PLANNING CONSULTATION RESPONSE

Application No	2025/0831
Proposal	2025 0831 C of U Vacant Club to F1e to 3x Resi Units C3 - Brierley Village Club Church Street Brierley
Address	Brierley Village Club Church Street Brierley
Date of Consultation Reply	01.12.25
Consultee	Tony Wiles Senior Conservation Officer

PROPOSED FRONT ELEVATION

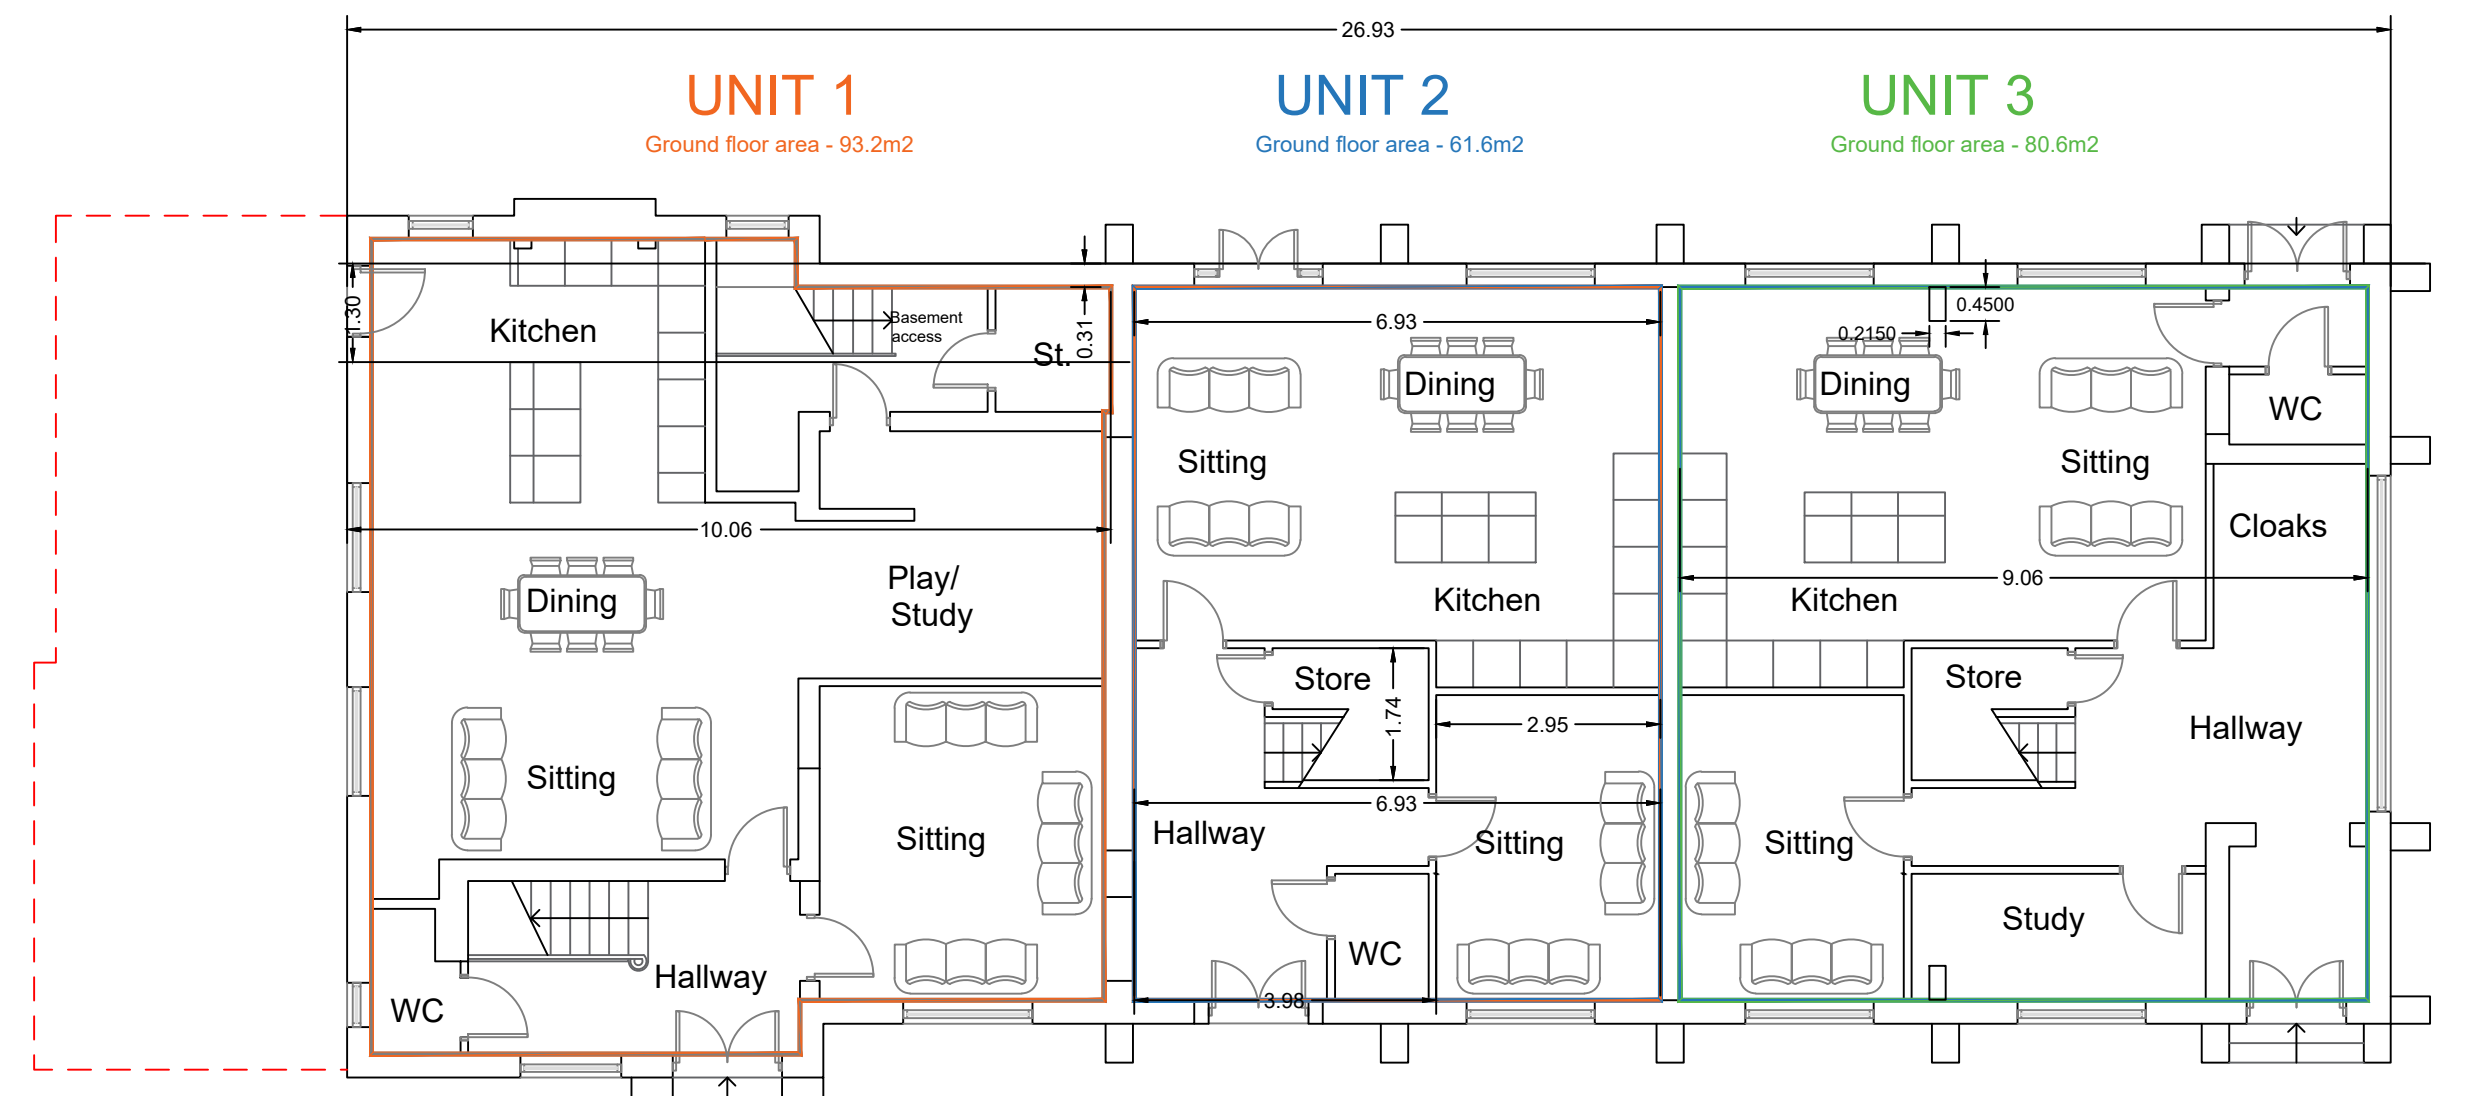
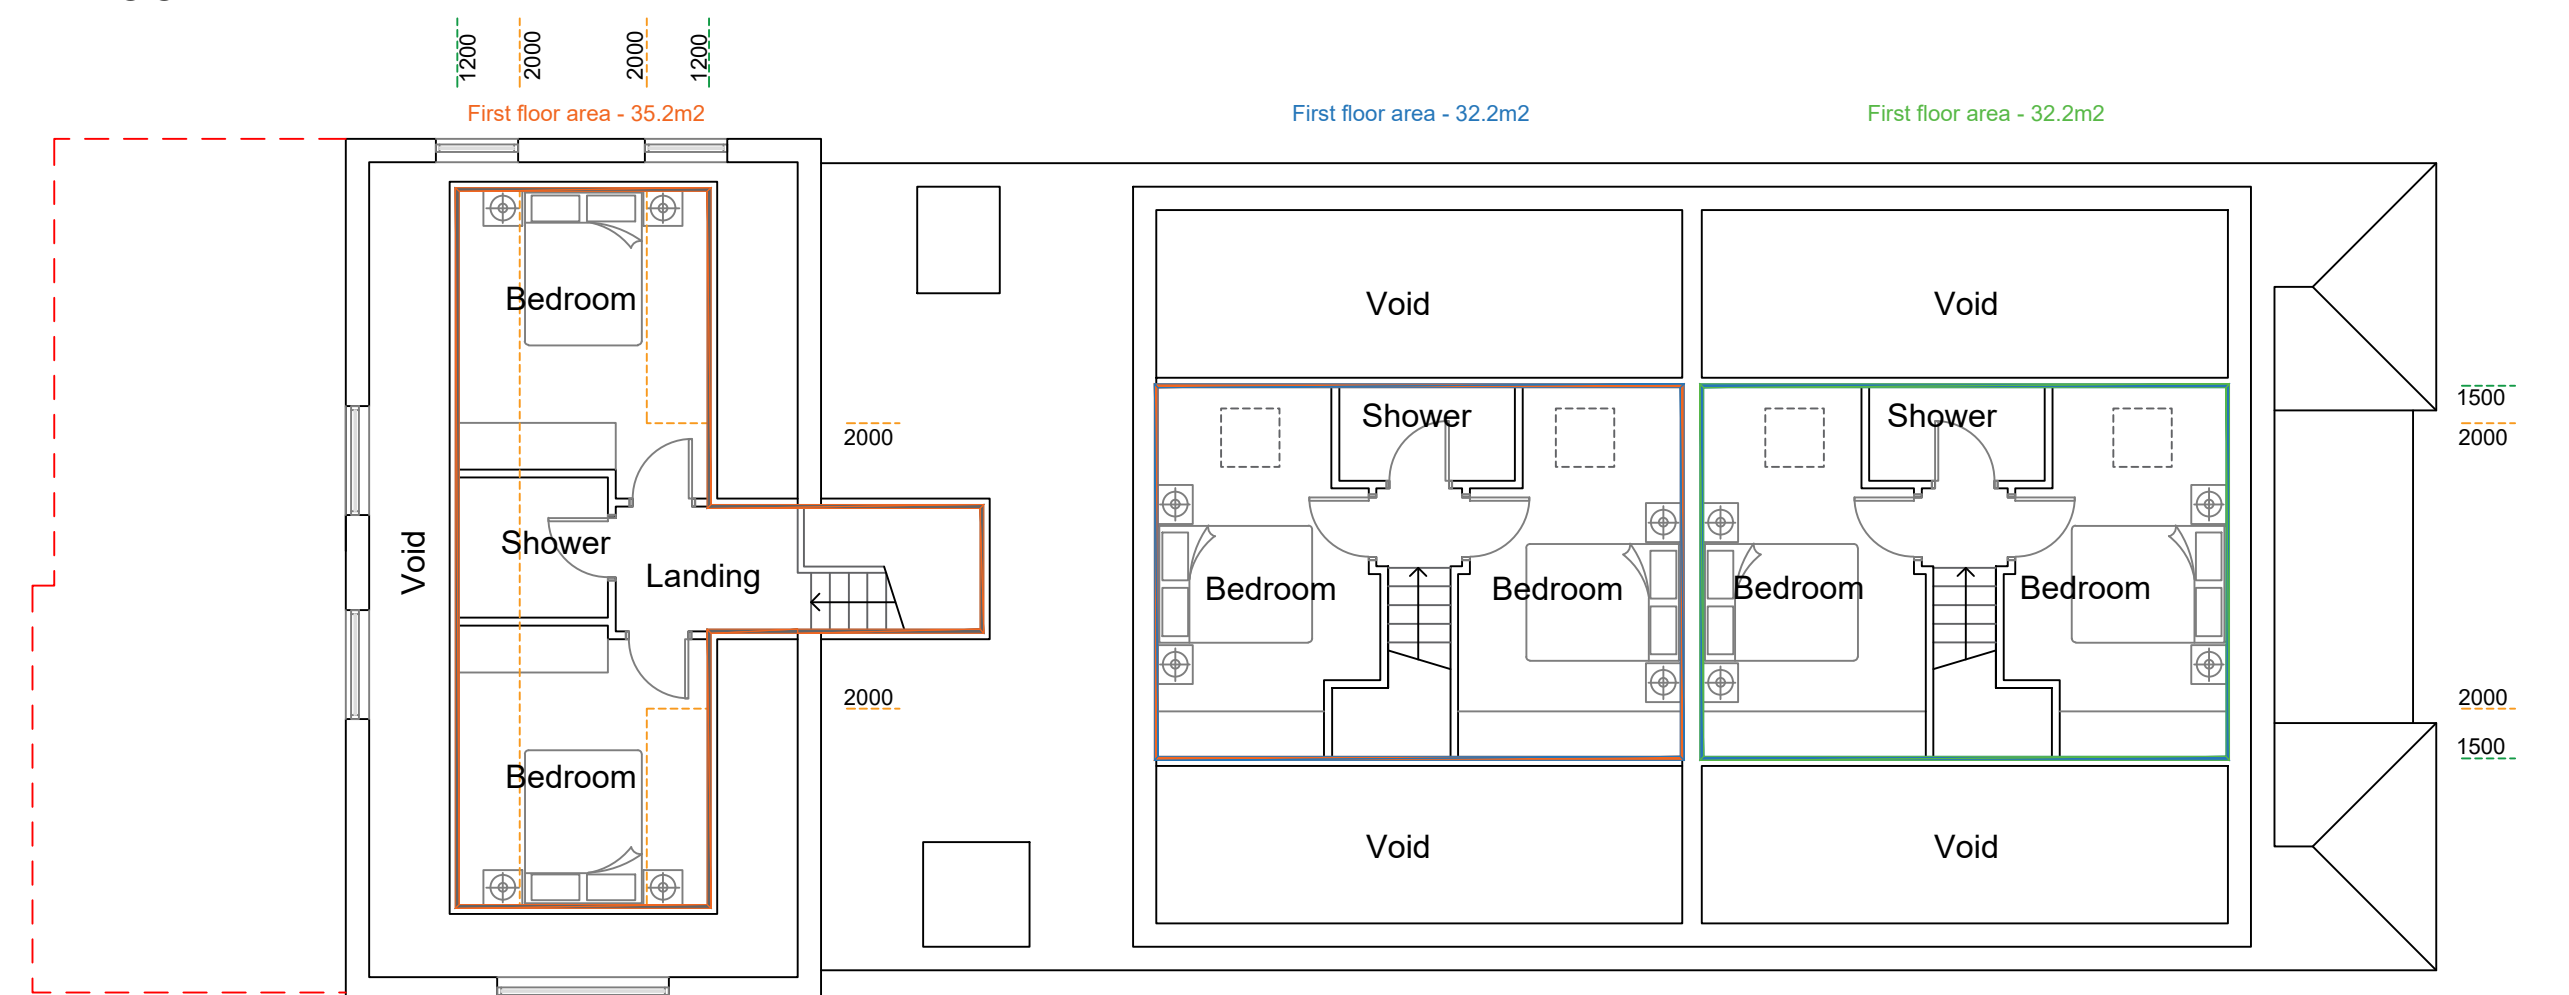
The proposal seeks to convert the building to residential. Currently, there is living accommodation and bedroom provision in the southern end (third) of the building, with the remaining space set out as the village hall. The plans show the subdivision and conversion of the hall space into a further 2x self-contained flats (making three in total) over three floors. The ground floor is given over to large open plan kitchen diners / sitting rooms and secondary sitting rooms, hallways and stairs. The new first and second floors include five bedrooms (each) with bathrooms and en-suites over two floors. To accommodate the new use, alterations are proposed to the large windows in the main elevations (front and rear) which are extended downwards to accommodate the new floor levels within. Numerous roof lights are also proposed to illuminate the second-floor spaces. To the rear, French doors provide GF level access in place of 2x windows. On the front elevation, I also note the large window in the fourth bay is omitted and replaced by a door (plus a surround to match the northeastern doorway). The later flat roofed toilet extension is removed and the 3x windows are inserted into this area at GF level.

I feel that the alteration of the openings to allow light into the GF is (on balance) justified and does not unduly harm or unbalance the elevations. However, the detail of the window design and material is lacking. Given the influence these windows have on the overall appearance of the building, I feel upvc is not appropriate and could harm and reduce its contribution to the conservation area. As such, repair and re-use would be the ideal with secondary glazing. An alternative would be quality timber or metal double glazed windows which would maintain the appearance and quality of the elevations and improve their thermal performance. Similarly, the rooflights should be genuine conservation specific rooflights, low in profile, with a single vertical divider in black. The demolition of the flat roofed toilet block is of little consequence and the new windows on the GF southern elevation are acceptable. The rear French doors are somewhat out of keeping in terms of their style and appearance but generally retain the proportions (mainly the width) of the existing windows in these bays. I note the suggestion of stone and brick surrounds to reflect the treatment of existing doorways surrounds which is welcomed. Similarly, whilst the new

doorway to the front elevation involves the loss of a window, its surround appears to be in brick and ashlar to match that of the northeastern corner door. I feel this is acceptable and does not unduly alter the overall balance or harm the appearance of the elevation. Lastly, the submission includes little detail of the outdoor space each property will have. There is a grassed area to the front of the building onto the roadside, but little detail is provided. This is a significant issue that requires clarification. Currently I can see no specific outdoor garden or amenity space shown on the plans.

- Generally, the treatment of the window and door openings in terms of materials and their detailed design plus stone and brick surrounds needs clarification. This should include the materials used and representative elevational and sectional plans including elevations at 1:20 scale of each door or window type and 1:5 scale cross-sections.
- Renewed doors and windows should be mounted in the reveal a minimum of 100mm
- Rooflights to be genuine conservation style rooflights, with black framing, a single vertical divider, and low profile.
- Generally, materials used in repair, making good, or alteration need clarifying and this could be conditioned on approval.
- The provision of dedicated outdoor space for each unit is not shown and should be clarified.
